Councillor

Customer made comments neither objecting to or supporting the Planning Application

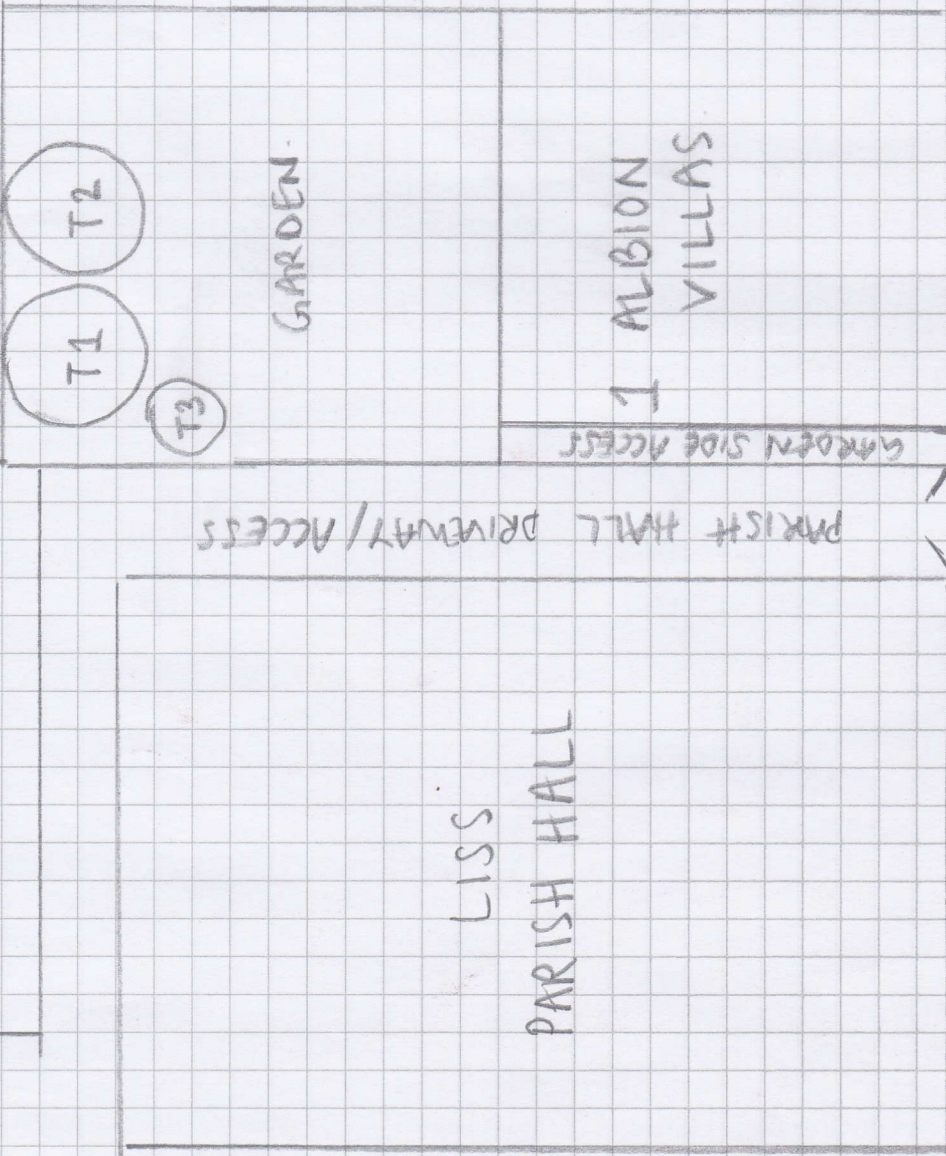
Trees T1 and T2 are on the garden boundary that faces almost directly due east. Therefore the shading effect of these trees should be much less severe than the height may suggest.

The fall of pines tends to be very localised to around the base of the trees.

I think that sympathetic pruning of tree T3 would be more appropriate than a straight crown reduction.
